WEST SUSSEX COUNTY COUNCIL CONSULTATION

TO:	Arun District Council FAO: Hebe Smith
FROM:	Highways, WSCC
DATE:	11/08/2026
LOCATION:	The Grange, Westergate Street, Westergate, PO20 3SQ
SUBJECT:	AL/52/26/PL Removal of mobile home and replacement with 1 No. self-build dwelling and associated works. This application is in CIL Zone 1 (Zero Rated).
DATE OF SITE VISIT:	N/A
RECOMMENDATION:	Advice

PROPOSED SITE AND ROOF PLAN

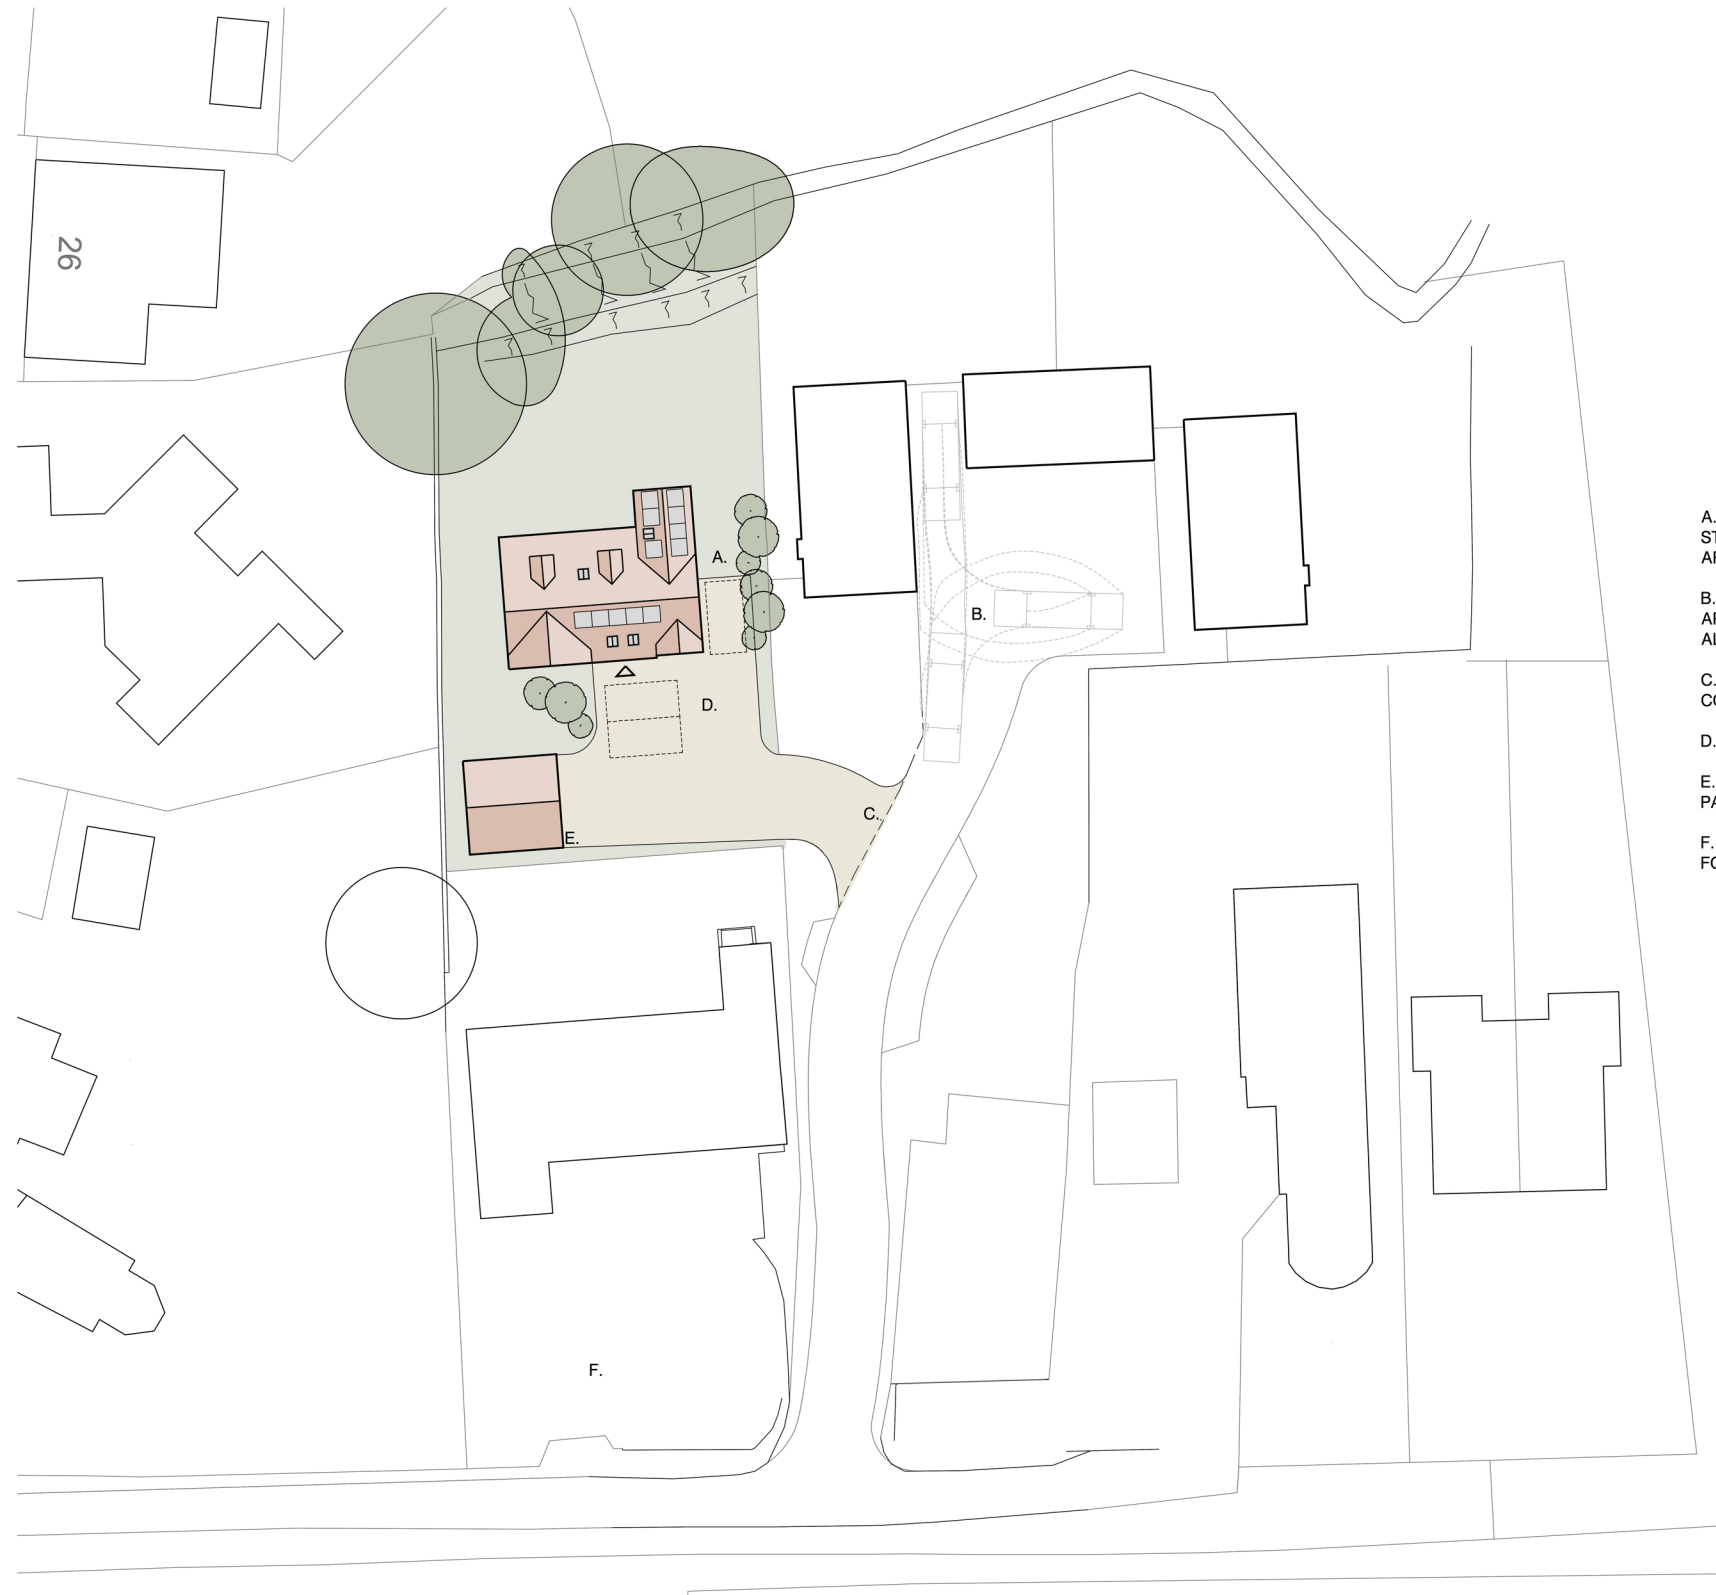
Regarding parking, a driveway with space for at least three cars is proposed, along with a detached double-bay garage. The proposed parking provision would be in accordance with Arun Parking Standards for a dwelling of this size and location. On-site turning appears achievable, allowing cars to exit the site in a forward gear. Swept path tracking has also demonstrated that a refuse vehicle/fire appliance can service the site and exit in a forward gear.

Car parking space (details approved)

No part of the development shall be first occupied until the car parking has been constructed in accordance with the approved site plan. These spaces shall thereafter be retained at all times for their designated purpose.
